Re: Planning Application AW/246/19/PL

Land Adjacent to 34 Wakefield Way Aldwick PO21 3RS

Reference: - AW/246/19/PL – Erection of 1 No. 2 Storey End of Terrace House

OBJECTION TO THE AFOREMENTIONED APPLICATION

PROJECT	Wakefield Way	DATE	19/08/19
TITLE	Site Plans	DRG NO	IBA/520/01
SCALE	As Noted	REVISIONS

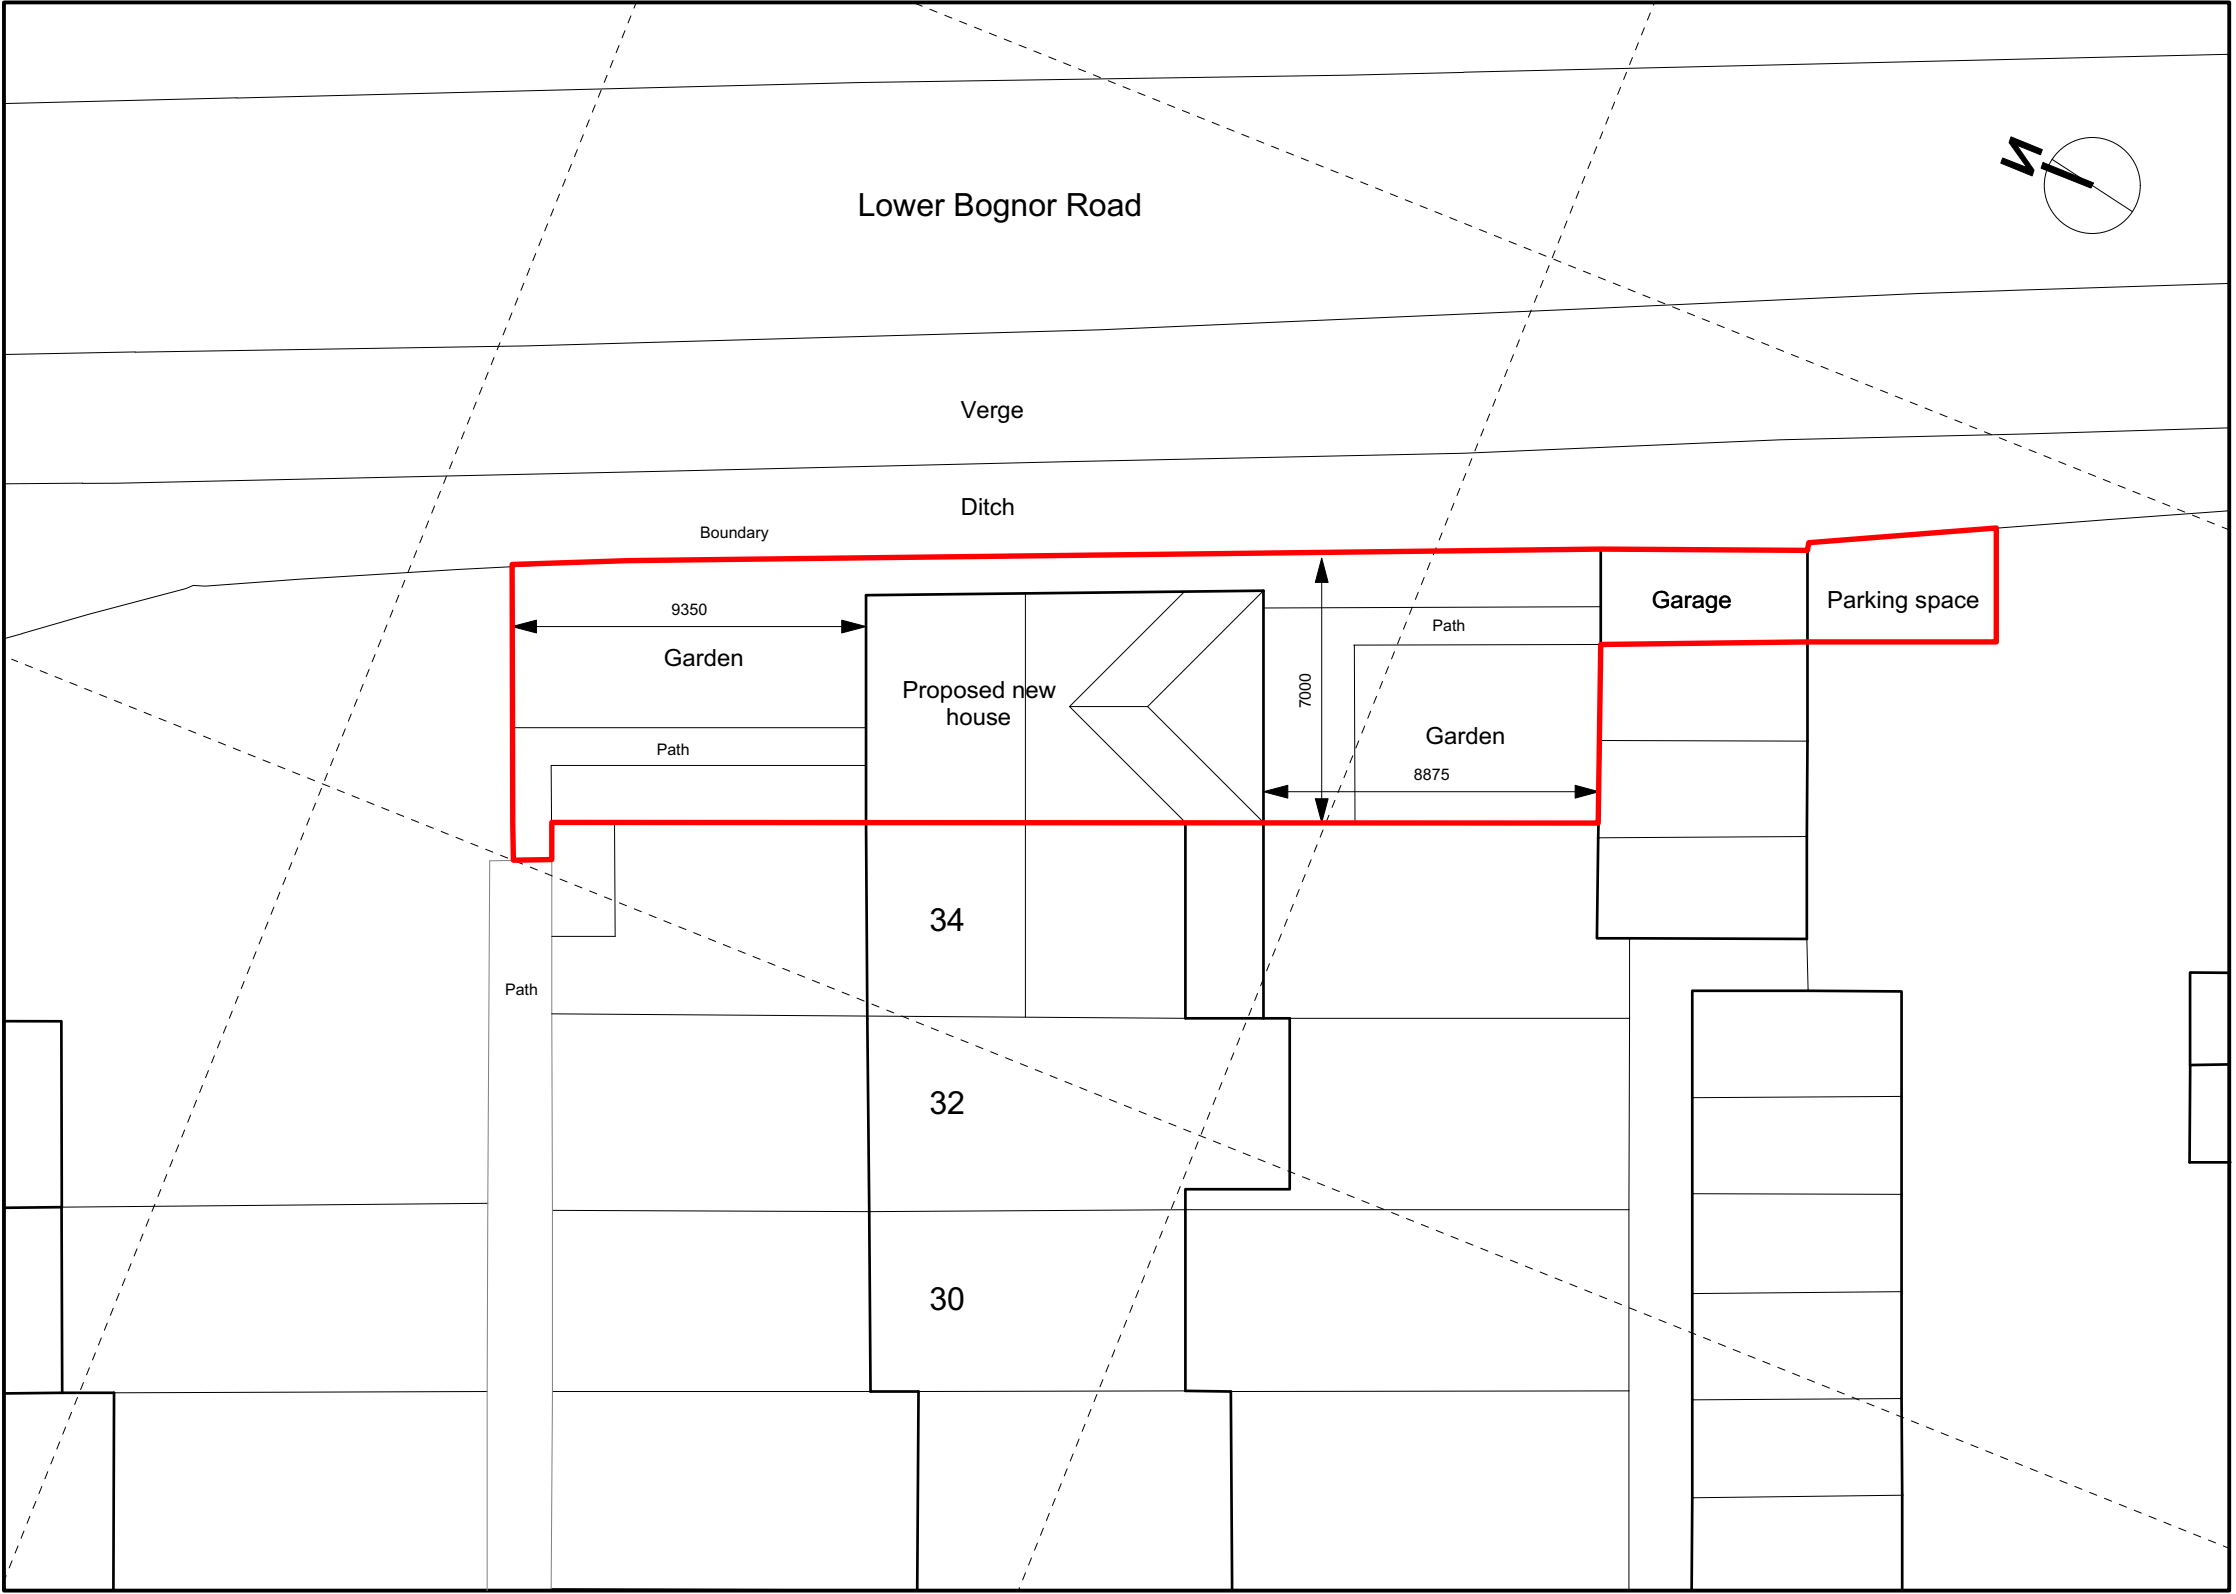
I refer specifically to IBA Drawings IBA/520/01, 02 & 03.

In paragraph 2 of the Design and Access Statement on Page 5 of the self-named document, I quote *"Parking is provided on site, with one garage space and one parking space in front of the garage"*

According to the WSCC Consultation on the planning application the WSCC PDC requires a minimum of three parking spaces to be provided for this size dwelling in this location. According to the D&A Statement the proposal by the Applicant would only give 2.

It is our belief that neither of these two proposed spaces constitute a parking provision for the dwelling.

The first of which is a garage situated at the far end of the L/H side of the garage block. This garage is apportioned to No.34 (the existing dwelling) therefore no "additional" space has been created, it has simply been re-assigned from an existing dwelling to the proposed. This conclusion has also been noted within the WSCC Consultation.

There is also a further point to the proposed use of a garage as a parking space within this application. As per the WSCC Consultation, the garage in question is only 2.5m wide and 5.5m long. This is barely big enough for a standard size family vehicle. However, the Design and Access Statement submitted makes note that the garage will also be the "Bin Store" for three wheeled refuse bins along with space for two bicycles. I do not see how a car, three wheelie bins and two bicycles will fit into this garage. The floor space is simply not enough.

Secondly the area of hard standing in front of the garage cannot be assigned to any one property as it does not fall within the ownership boundaries of the existing dwelling. I refer specifically to restrictive covenants stipulated in Section 2 of The First Schedule in the Transfer of Land document between Pennant Developments and the original purchaser of No. 34 Wakefield Way.

Therefore, no portion of the forecourt area can be apportioned to any one property as its title belongs to all persons entitled under the same Schedule accompanying their deeds.

In short, no provision of any spaces has been provided for the new dwelling, therefore not meeting the regulatory 3 spaces as set down by the WSCC in their PDC.
